WEST SUSSEX COUNTY COUNCIL CONSULTATION

TO:	Arun District Council FAO: Claire Potts
FROM:	Highways, WSCC
DATE:	5/07/2018
LOCATION:	Land south of, New Road (A259) & East of Brook, Angmering
SUBJECT:	A/11/17/OUT Hybrid Application to include Full planning permission for a retail unit (Class A1) comprising 1,487sqm with associated access, car parking, servicing, landscaping & associated works & Outline planning permission with some matters reserved (scale & appearance) for public house (Class A4) comprising 581sqm (resubmission following A/23/15/OUT). This application is a Departure from the Development Plan. Additional plans received.
DATE OF SITE VISIT:	
RECOMMENDATION:	☐ Advice ☐ Objection ☐ Modification ☒ No Objection ☐ More Information ☐ Refusal
S106 CONTRIBUTION TOTAL:	N/A

Following the deferral of planning application A/11/17/OUT at the May planning committee the applicant has submitted the following information:

- Redwood Partnership Drawing REDW-3167-132 Highway access plan
- Redwood Partnership Drawing REDW-3167-133 Highway works – connection to adjacent development

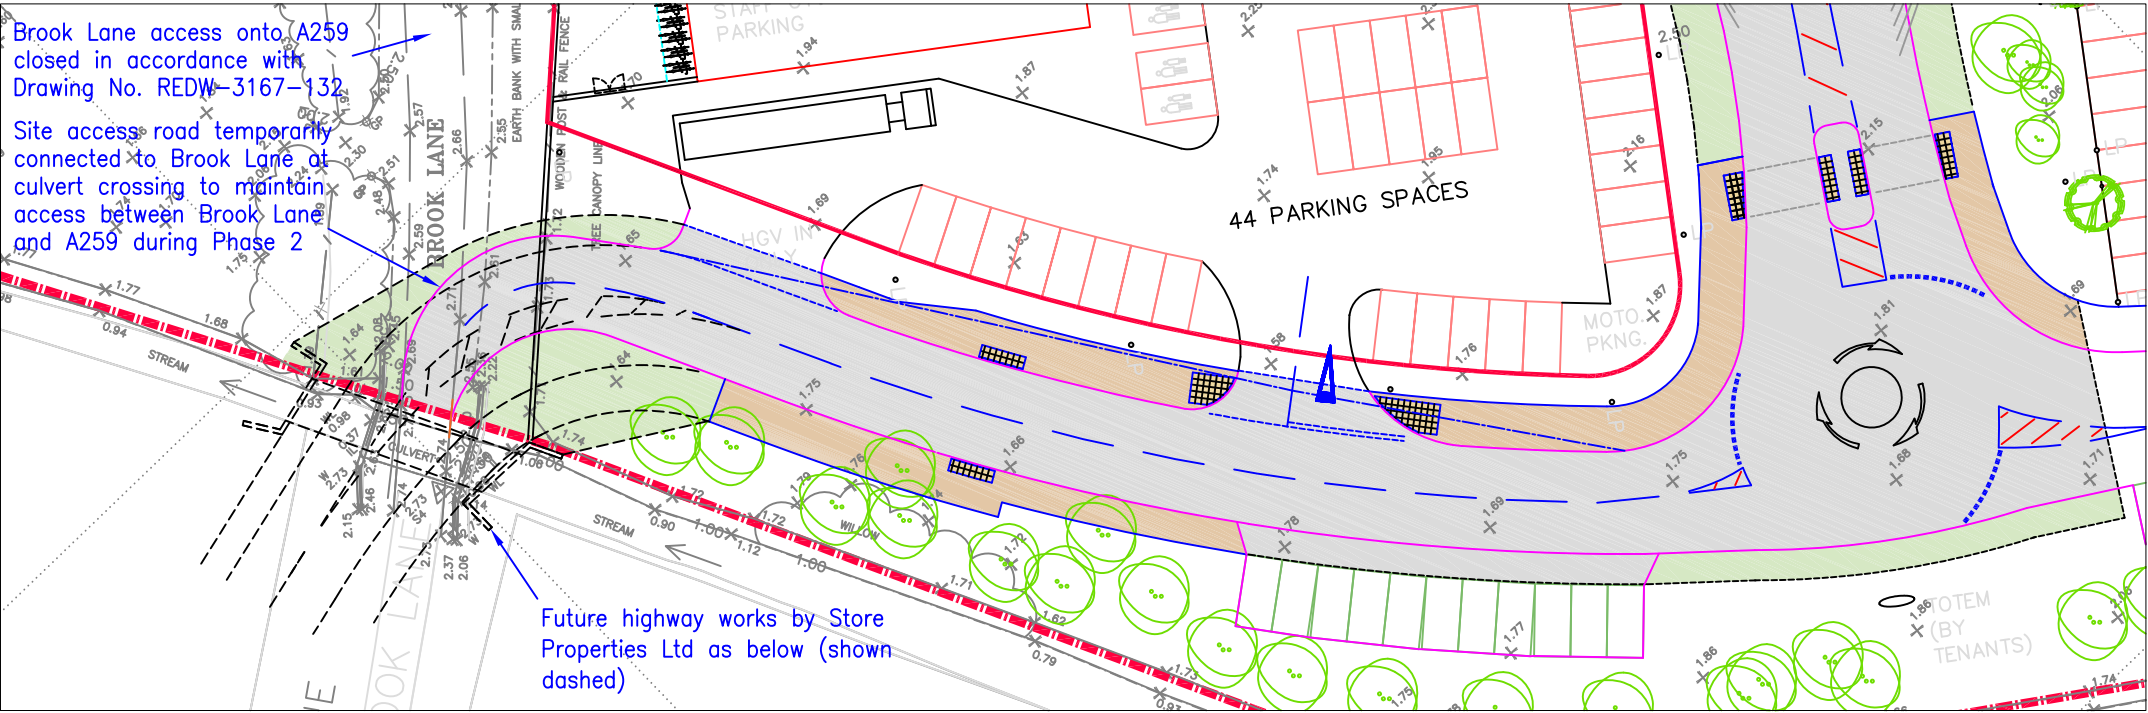
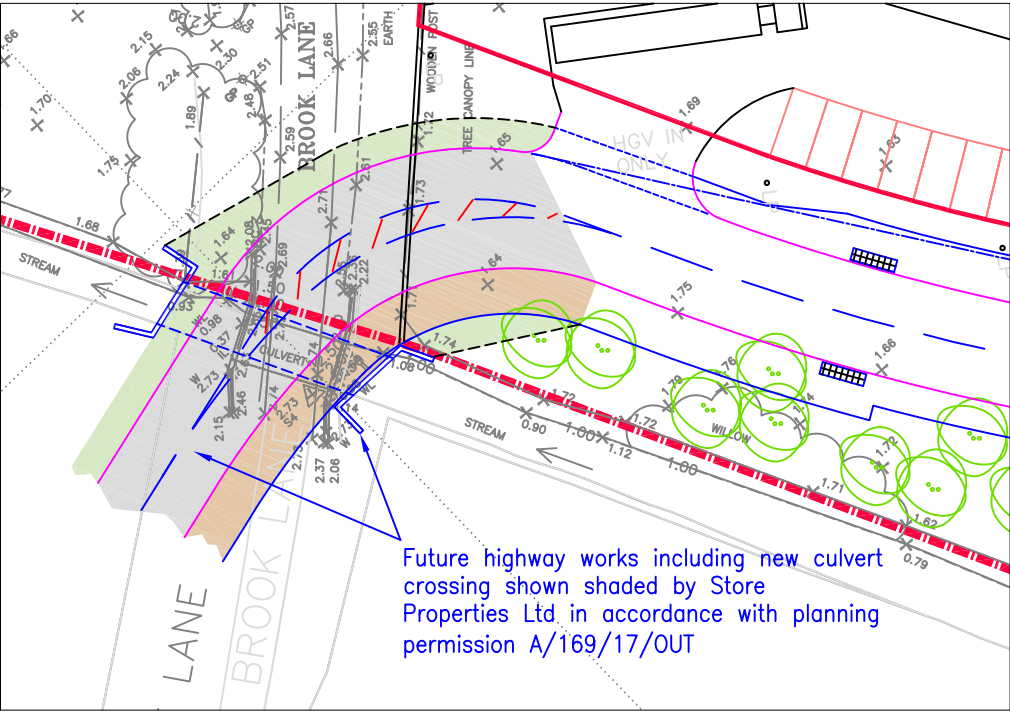
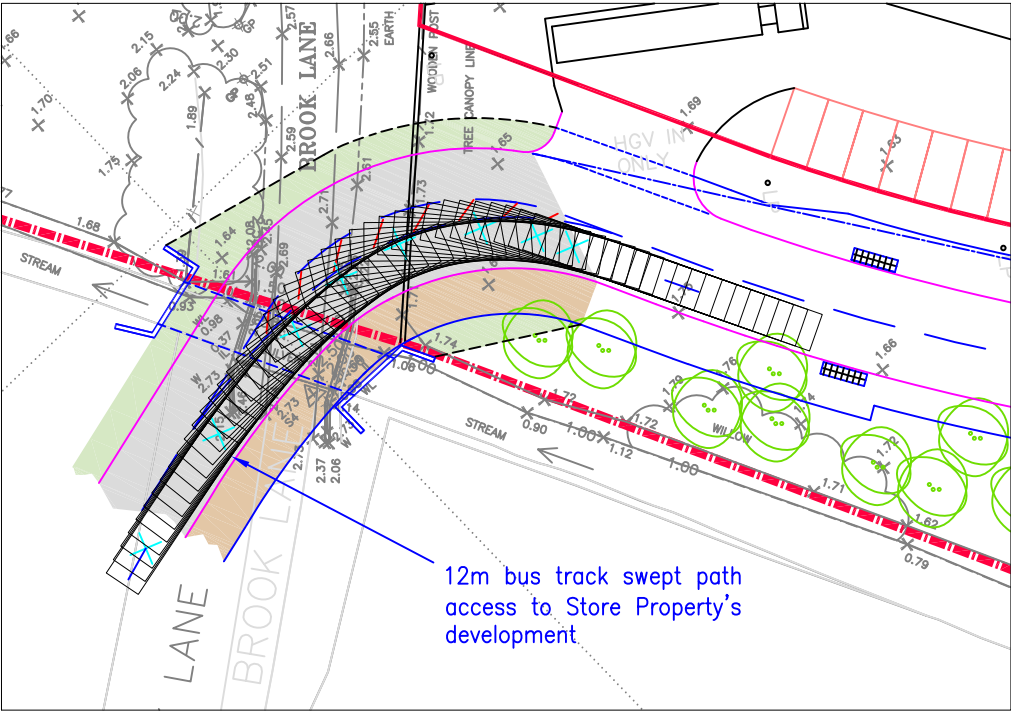
These plans demonstrate that access can be provided into the adjacent site; subject to agreement of rights of access which are a private and non-planning matter. The adjacent site has outline planning consent for residential units and a care home which were approved under A/169/17/OUT. Given that the applicant has demonstrated that the committed scheme A/169/17/OUT can still be accessed and that this application does not preclude the consented scheme from coming forward the Highway Authority would not object to this application.

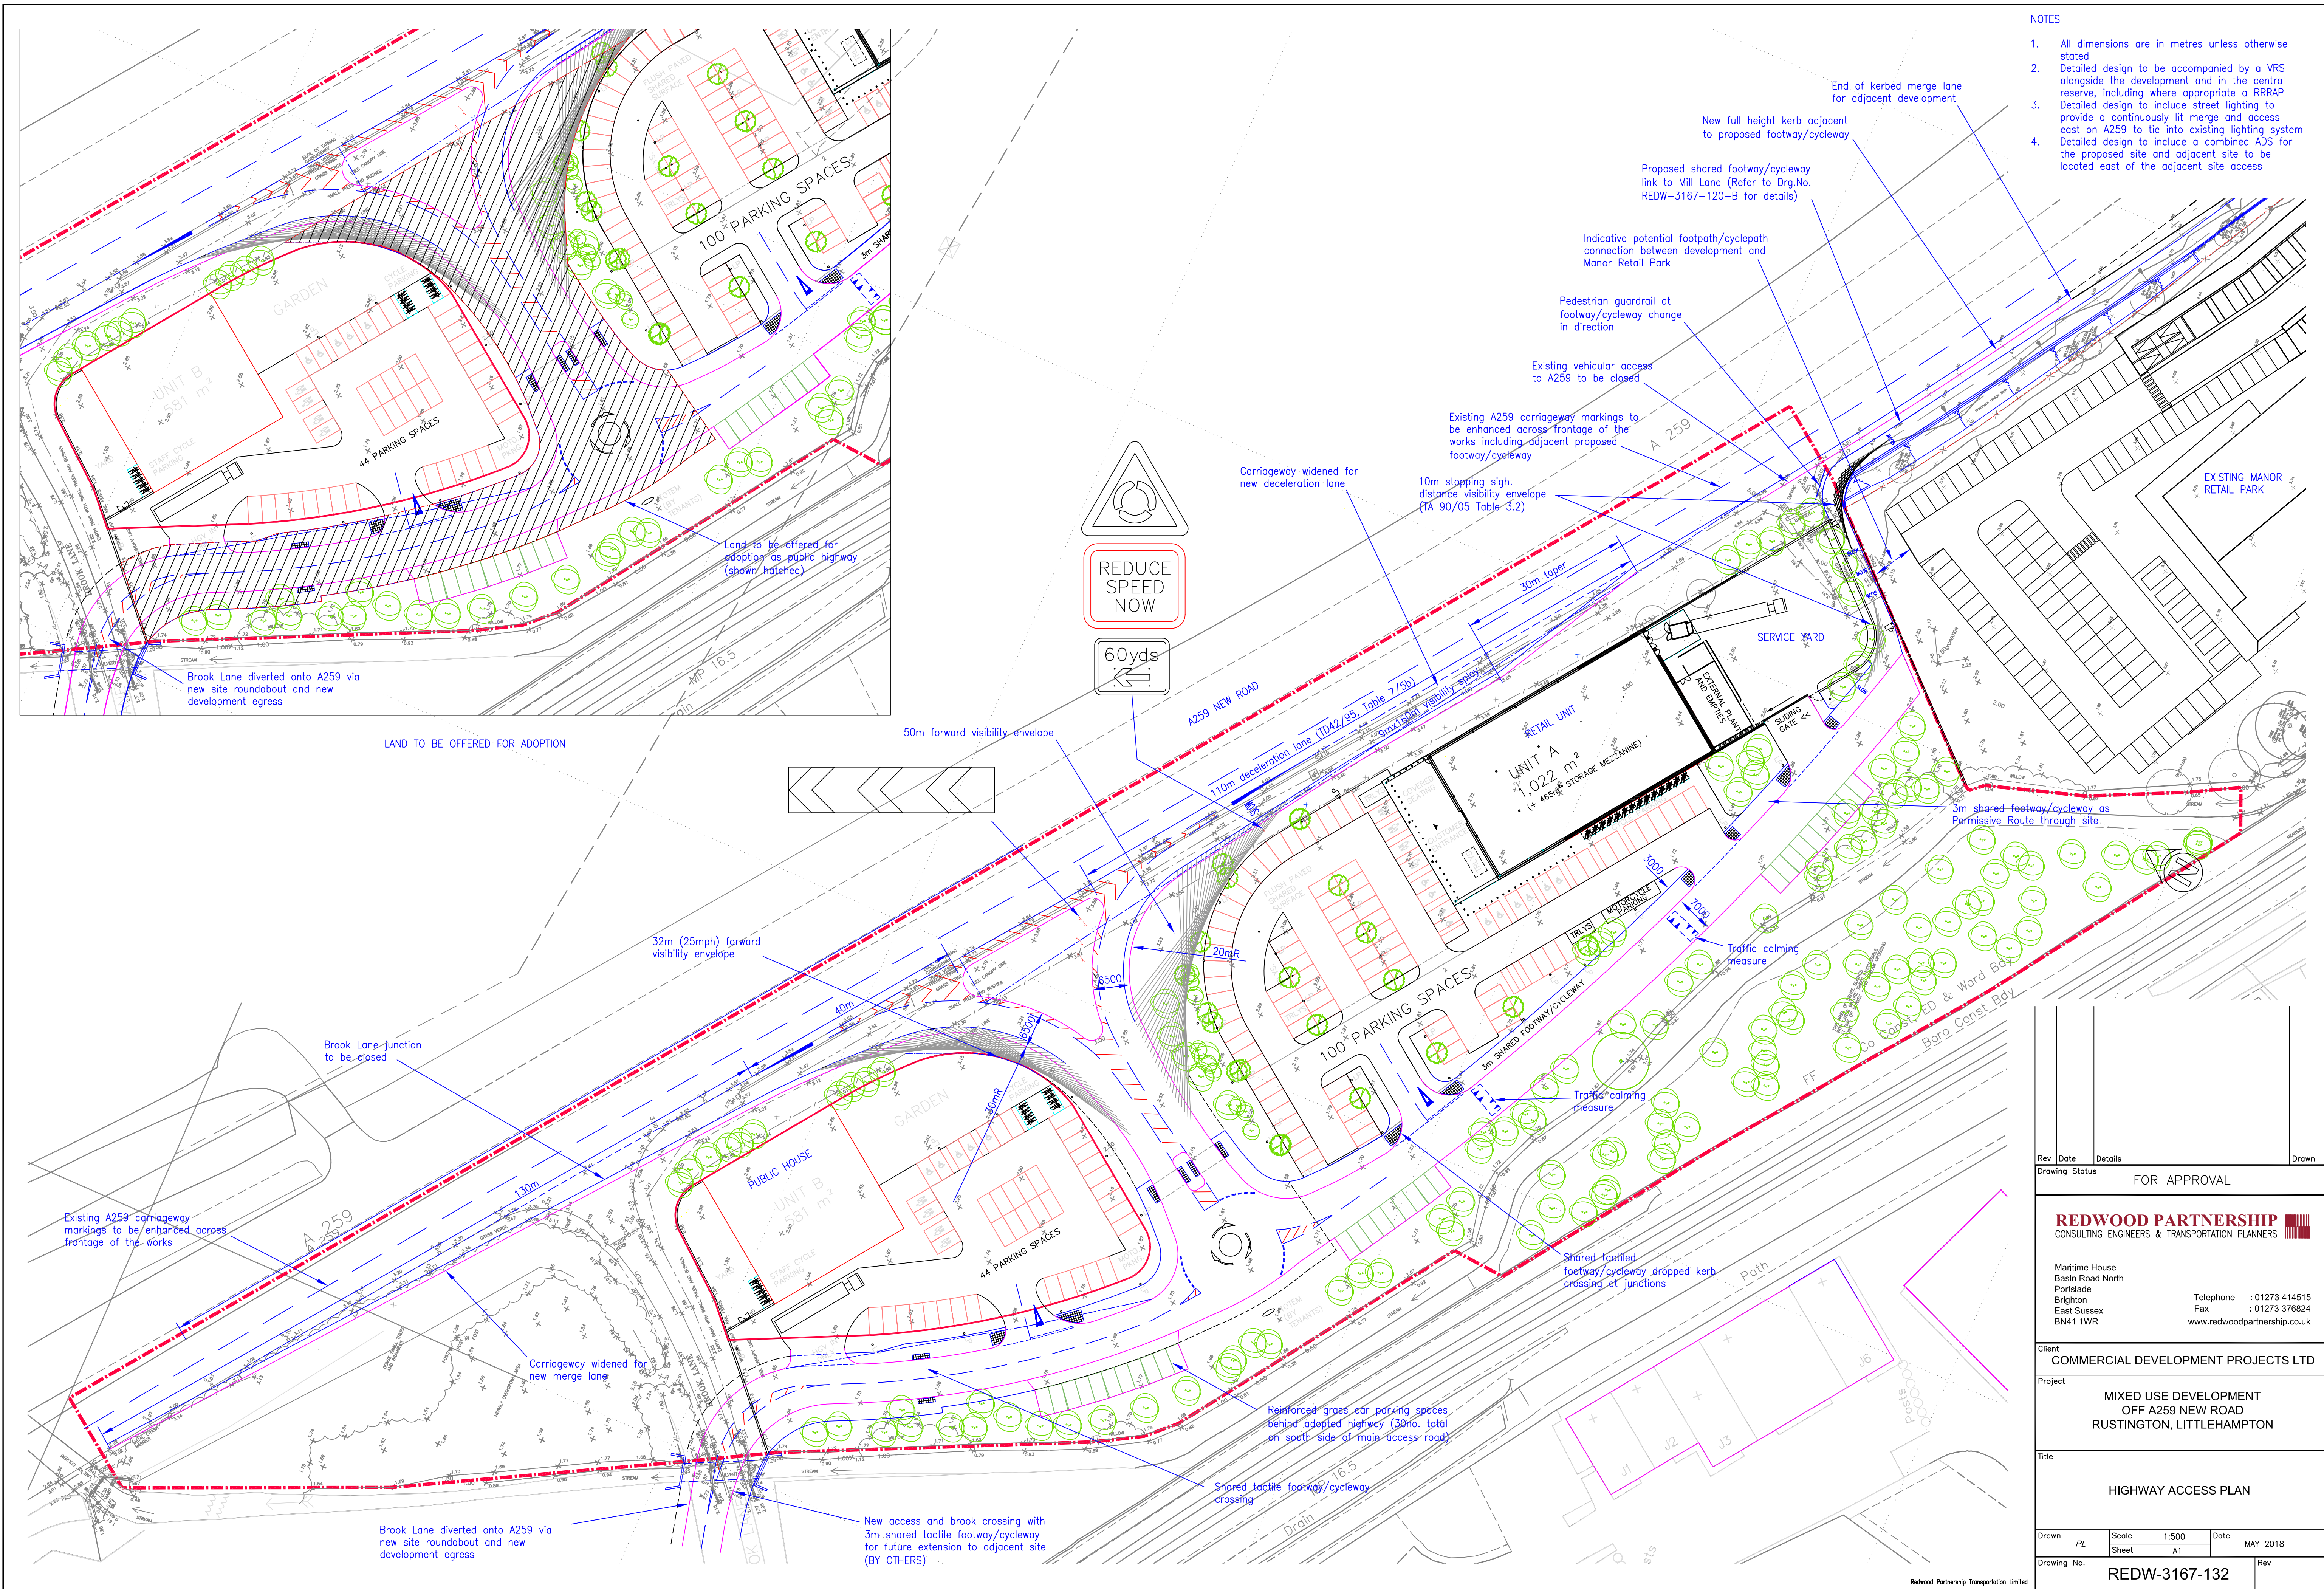
The applicant should also note that the Highway Authority would not be willing to adopt the internal access roads as has been indicated on drawing number REDW-3167-132 and these roads would remain private.
